<input type="checkbox"/> Sidewalk Waiver (Form V2)		
<b>SITE PLANS</b>		<input type="checkbox"/> Waiver to IDO (Form V2)	<b>APPEAL</b>
<input checked="" type="checkbox"/> DRB Site Plan (Form P2)	<input type="checkbox"/> Waiver to DPM (Form V2)	<input type="checkbox"/> Decision of DRB (Form A)	
<b>BRIEF DESCRIPTION OF REQUEST</b>			
Apartment complex development

**RE: Sonata Unit 4 Trails Apartments  
Tracts 1, 2, and 3, The Trails Unit 4  
Second DRB Submittal**

RESPEC, agent for Sonata Trails, LLC, owner of the above referenced property, is requesting approval from the Development Review Board (DRB) on this Site Development Plan submitted for your consideration. This is the second submittal to the DRB for this project. The first hearing was held on June 3, 2020. Below is a response to comments received at the first DRB meeting.

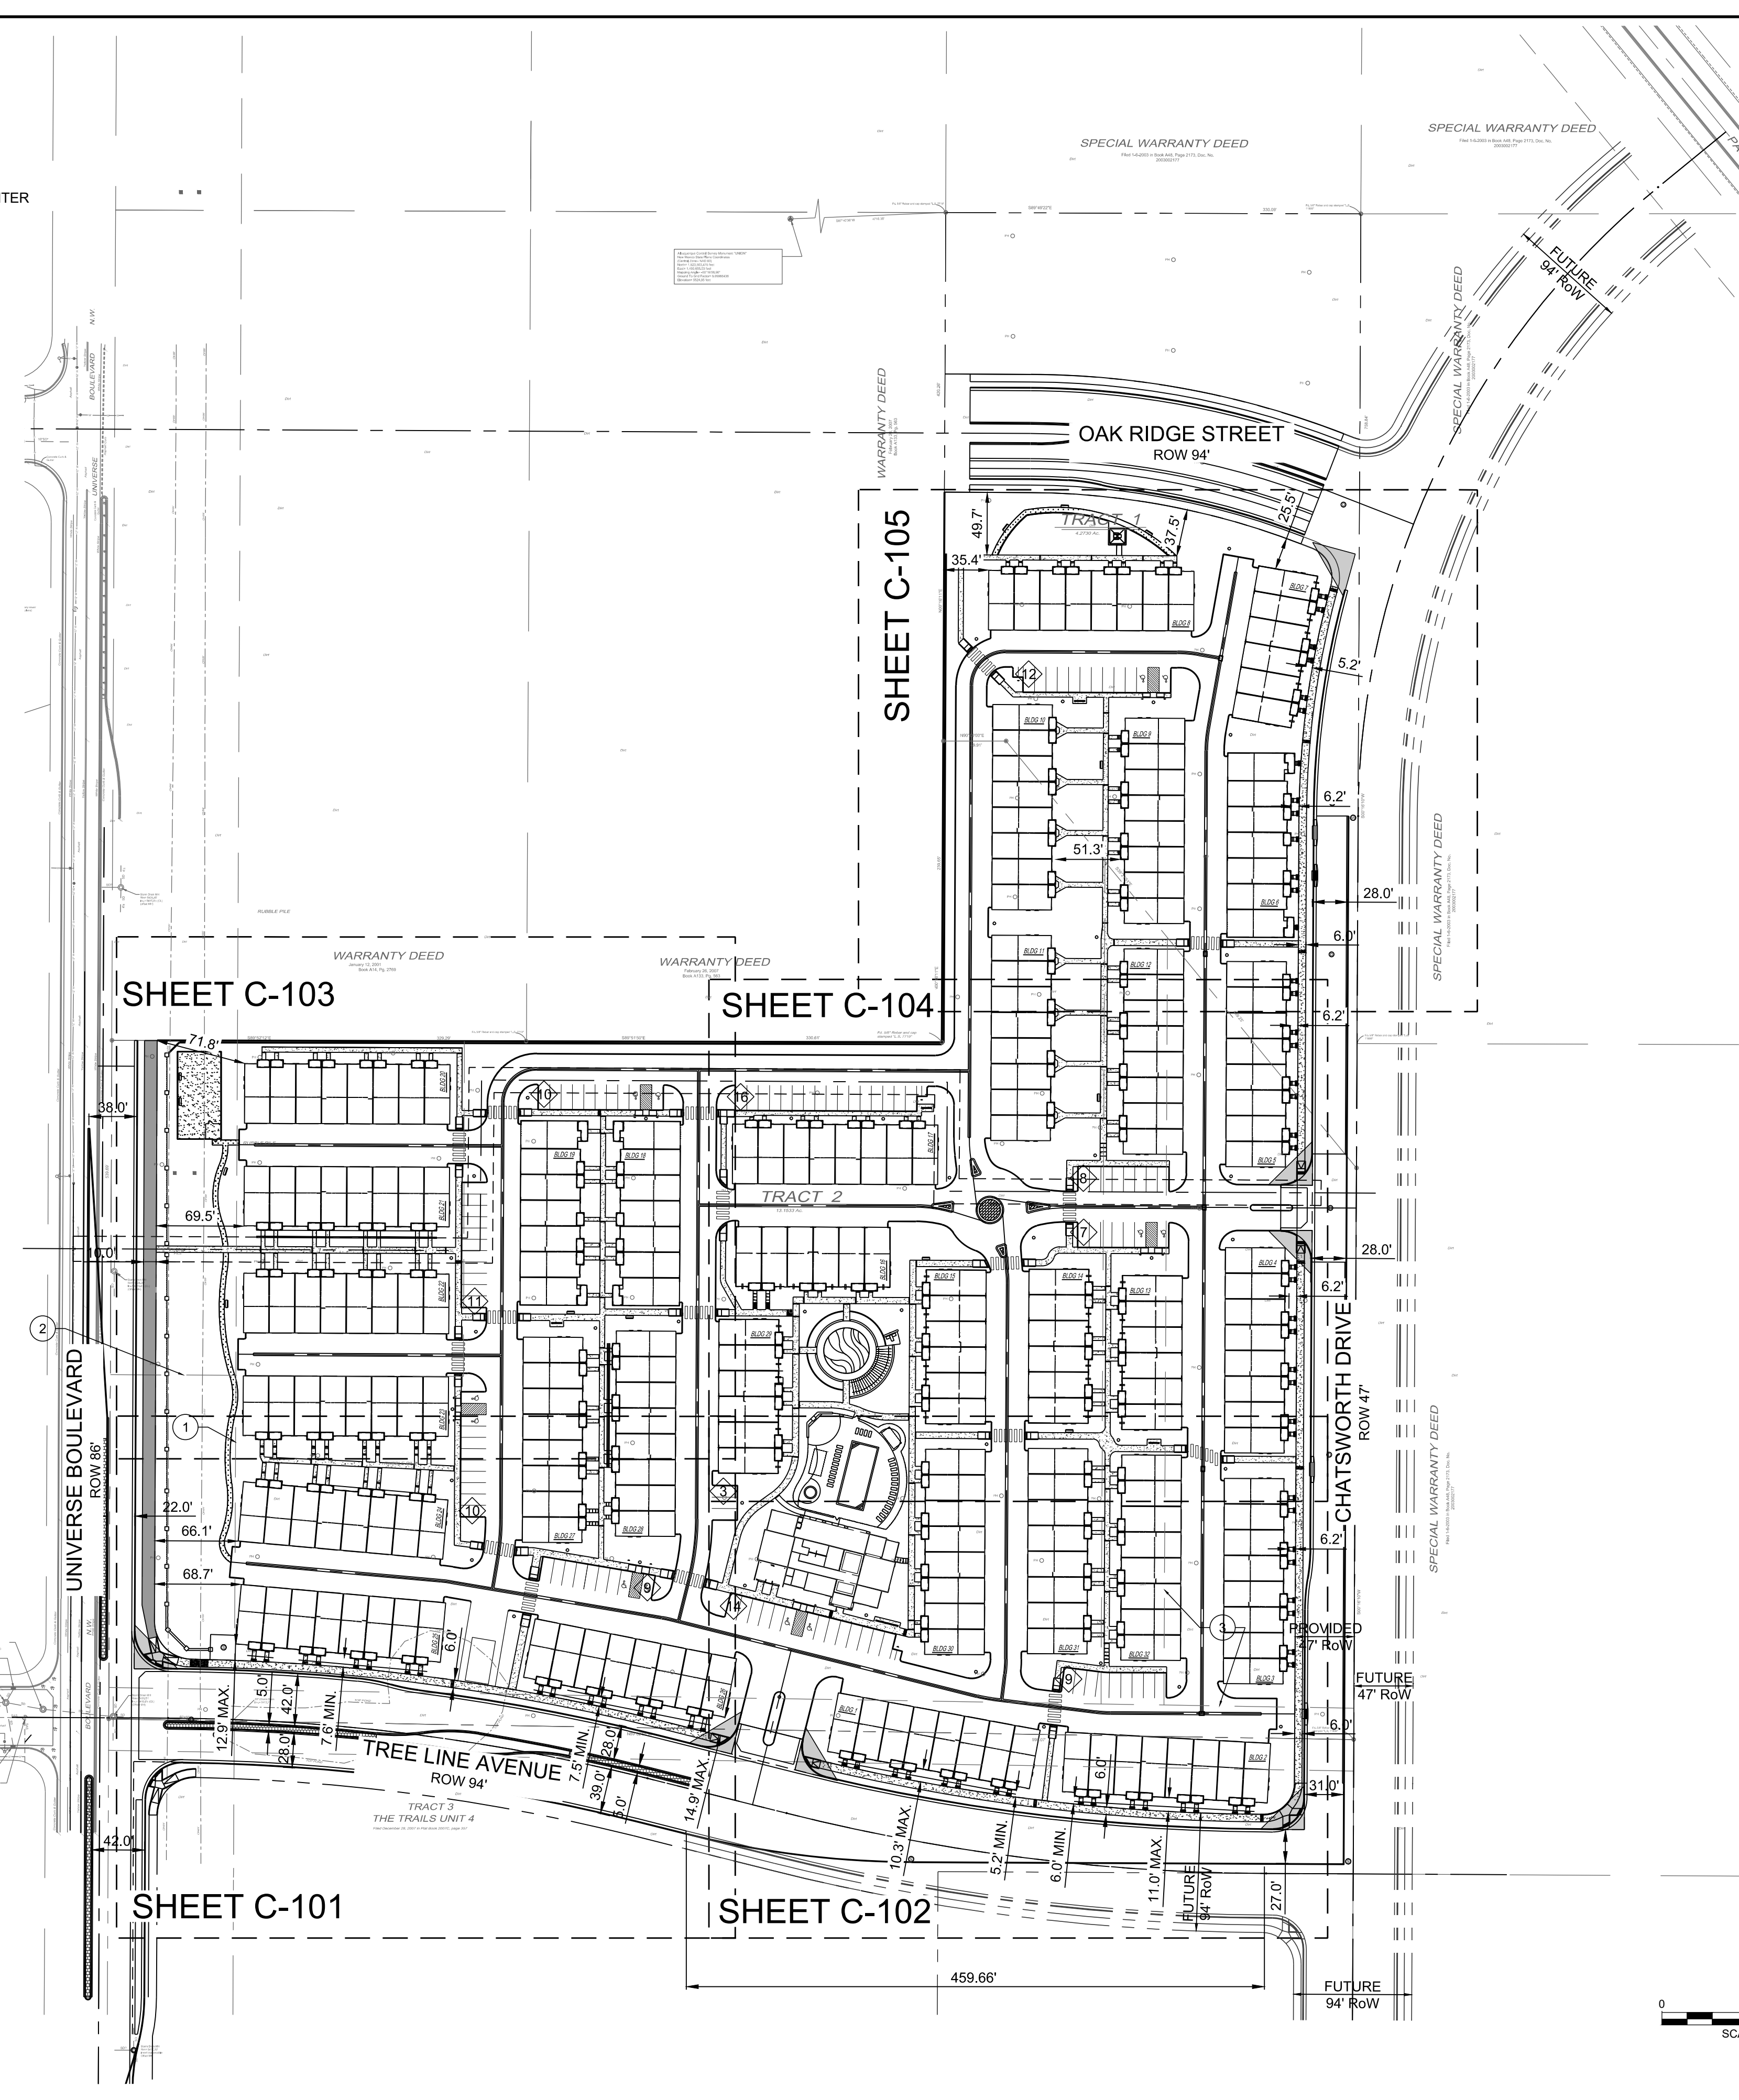
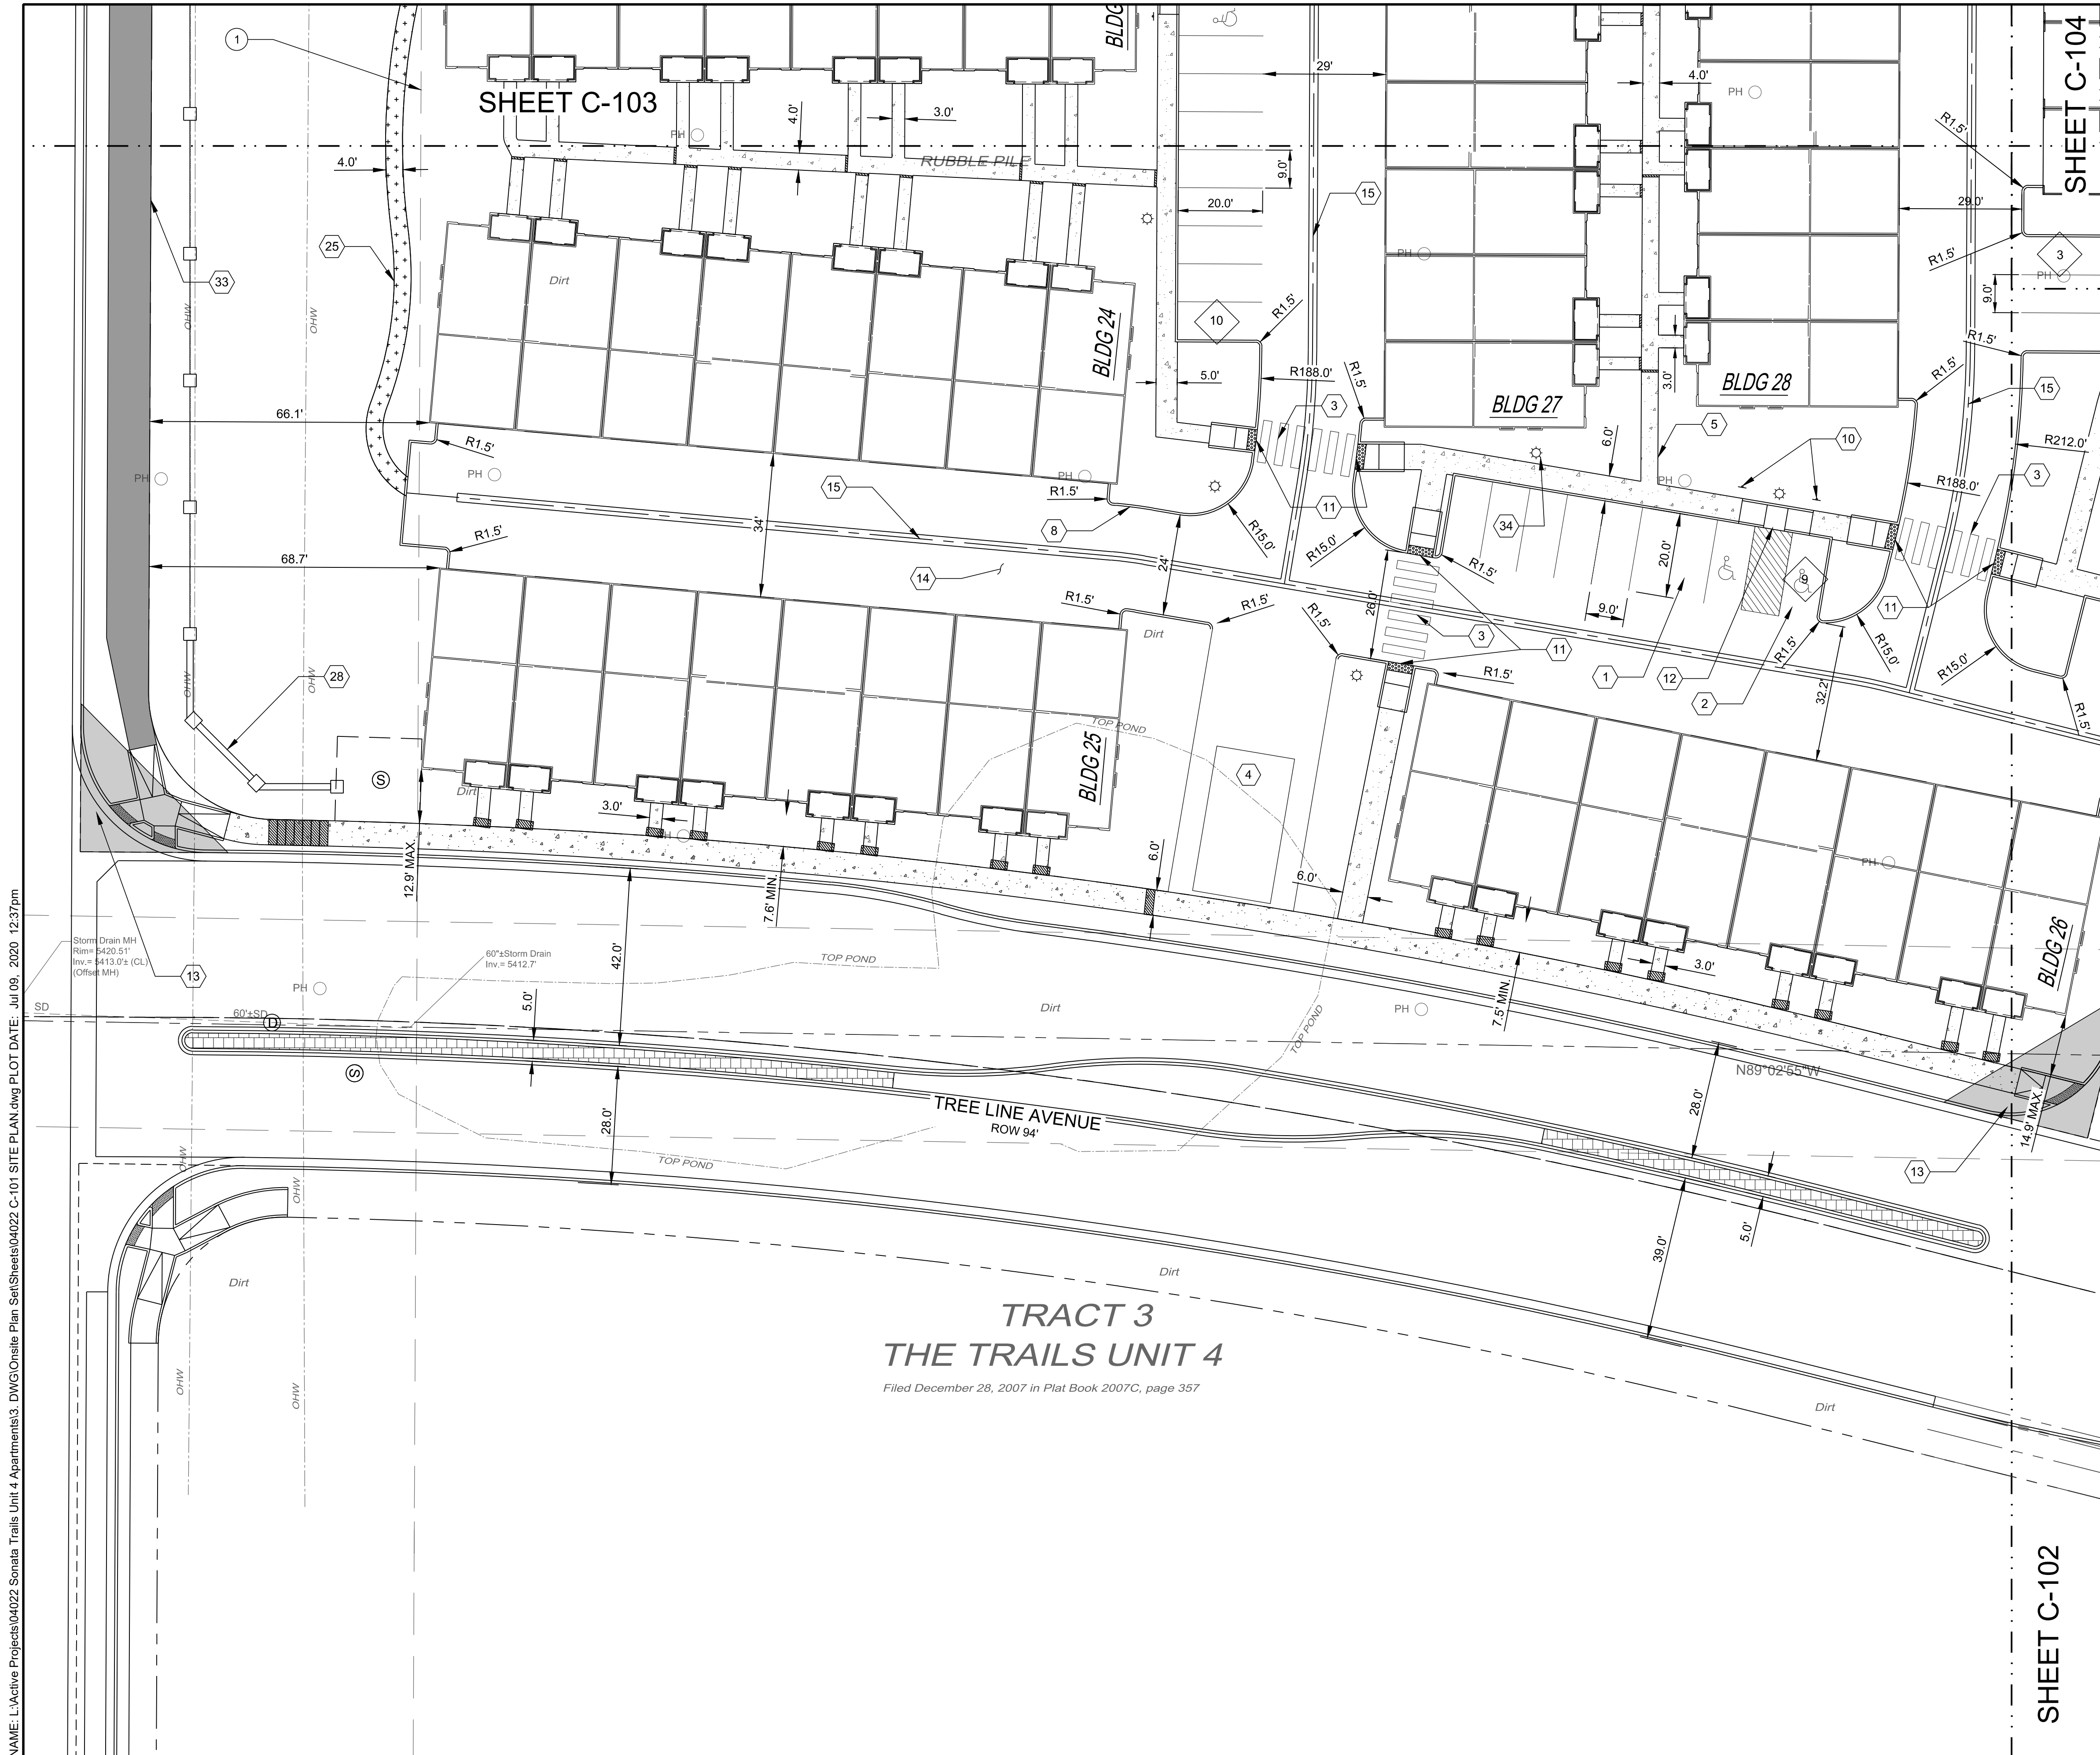
3. On the site plan, label roadway widths for surrounding streets that correspond with the roadway cross-sections and infrastructure list.  
/ Roadway width labels have been provided for adjacent streets. See revised site plan.

6. Add keyed notes for all ADA ramps on the site plan.  
/ Keyed notes 11 & 12 callout ADA ramps. The ADA ramp symbols have been added to the legend. See revised site plan.

9. Label all on-site walkway widths, and add a keyed note for crosswalks on the site plan.  
/ All on-site walkway widths have been labeled. A keyed note for crosswalks has been provided and a symbol has been provided in the legend. See revised site plan.

- The Code Enforcement signature line is missing from the Site Plan on Sheet C-100.  
/ Code Enforcement signature line has been added. See revised site plan.
- The Color, Reflectivity, and Roof-Mounted Equipment requirements for the Northwest Mesa Escarpment – VPO-2 must be met as listed below:

- The Site Plan mentions the proposed development as multi-family dwellings, but the design of the proposed dwellings seem to be townhomes. Please clarify this on the Site Plan.

- There appear to be pedestrian connections to sidewalks along the street frontages of Chatsworth Avenue and Treeline Avenue, but it's not clear on the Site Plan if there would be sidewalks along those frontages.

- Staff requests that benches be placed in the open space areas on the site outside of the central recreational area.
- / Benches were provided in the western open space area. Additional benches have been added throughout the site outside of the central recreational area. See revised site plan.

- / Four 1-bedroom units have been added to the second floor of the clubhouse building. We believe this meets the definition of a multi-family development rather than townhomes. See revised site plan.

- / Sidewalks and trails along property frontages will be built with this project. A hatch for off-site walkways has been added for clarity.
- Frontier Elm trees depicted on the Landscape Plan are not on the City of Albuquerque's Tree List.
